## DPE ISSUE 3 Response Attachment

## LEES1: Carslaw impacts

**An assessment is required to be undertaken which assesses the impact on the loss of natural light and resultant amenity to the occupants of the existing Carslaw building.**

Revised design for the Eastern Avenue interface - typical upper level plan

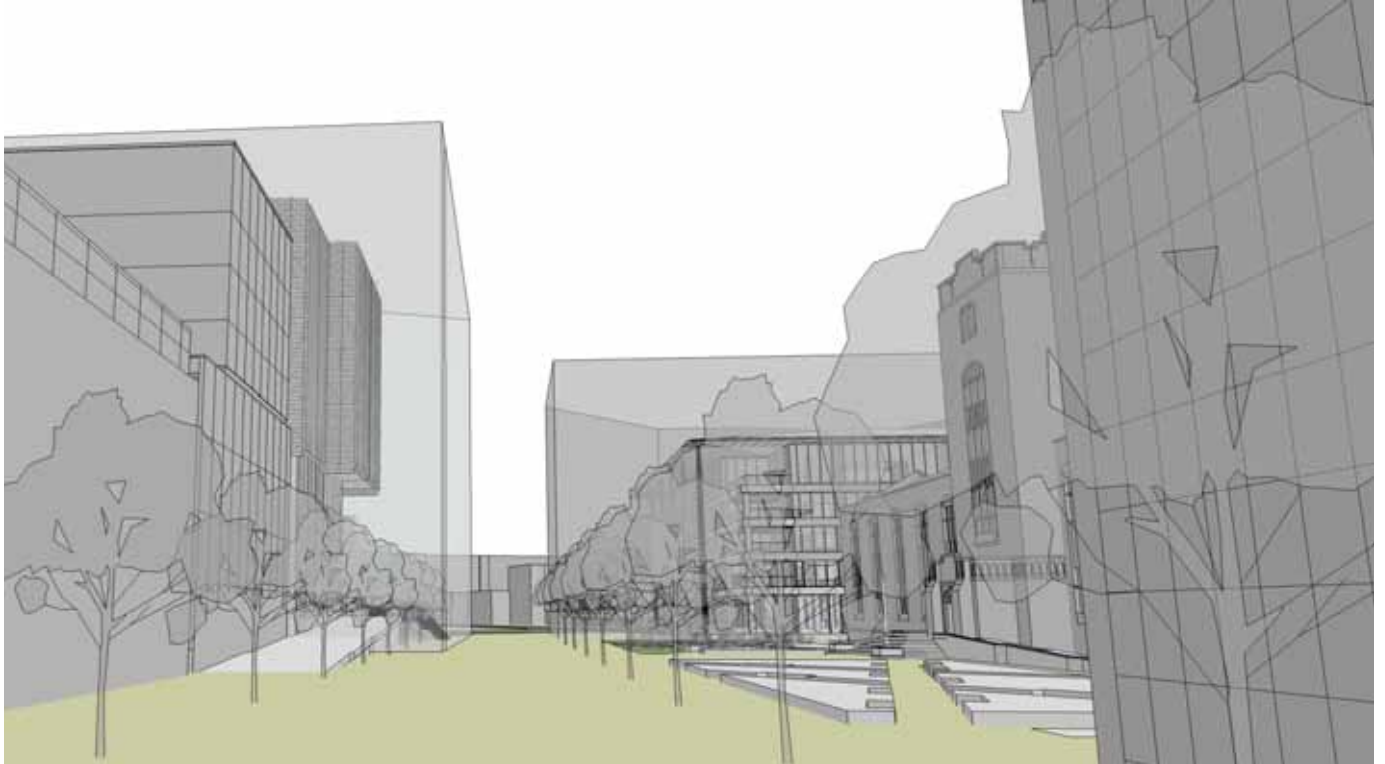
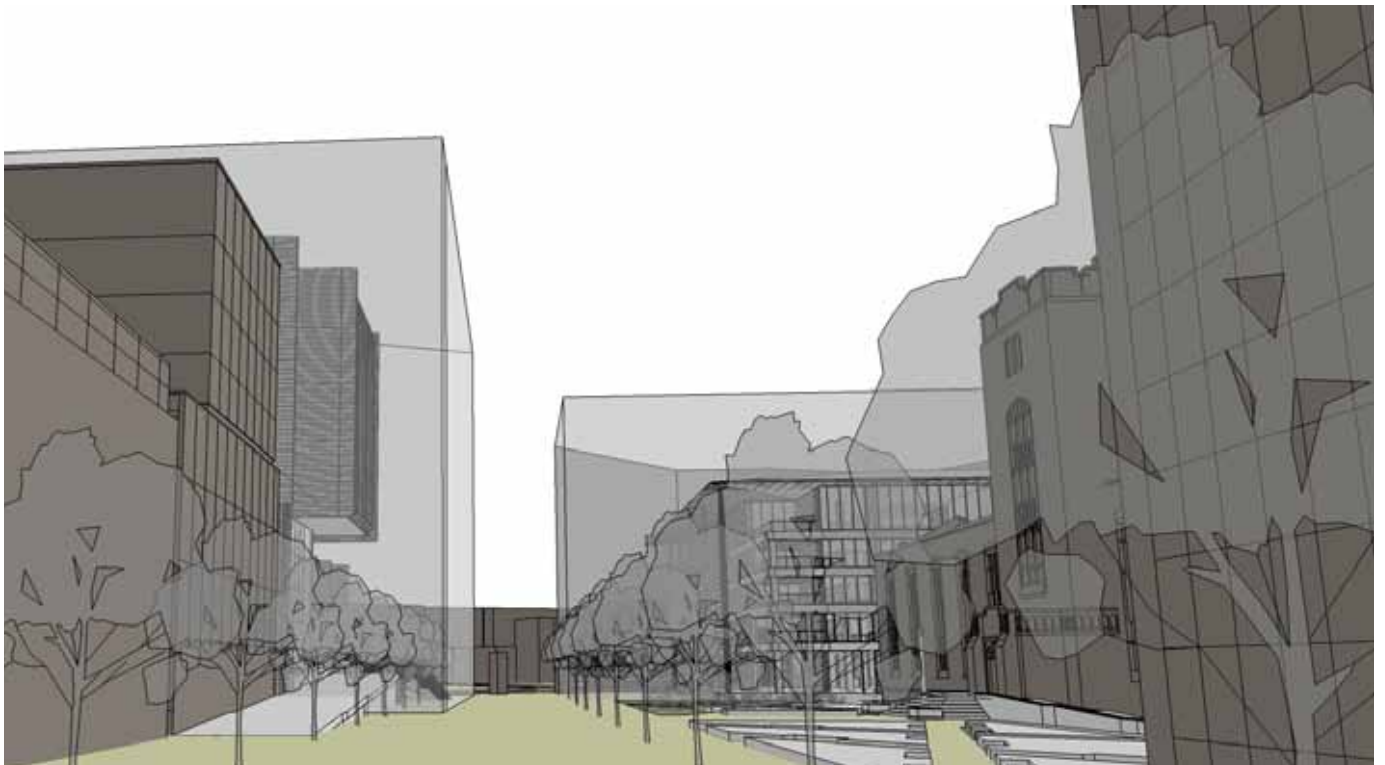
OGA Issue 3:  
The proposed encroachment of the western façade beyond the heritage alignment of Eastern Avenue is not supported.

It is important to note that there is no heritage basis to the building alignment of the eastern edge of Eastern Avenue. Eastern Avenue has taken many forms through the development of the campus over the last 100 years. Issues of alignment on Eastern Avenue are an urban design discussion, where issues of heritage frame a conversation around what the defining nature of the Camperdown Campus is, and how those qualities can be strengthened through new buildings.
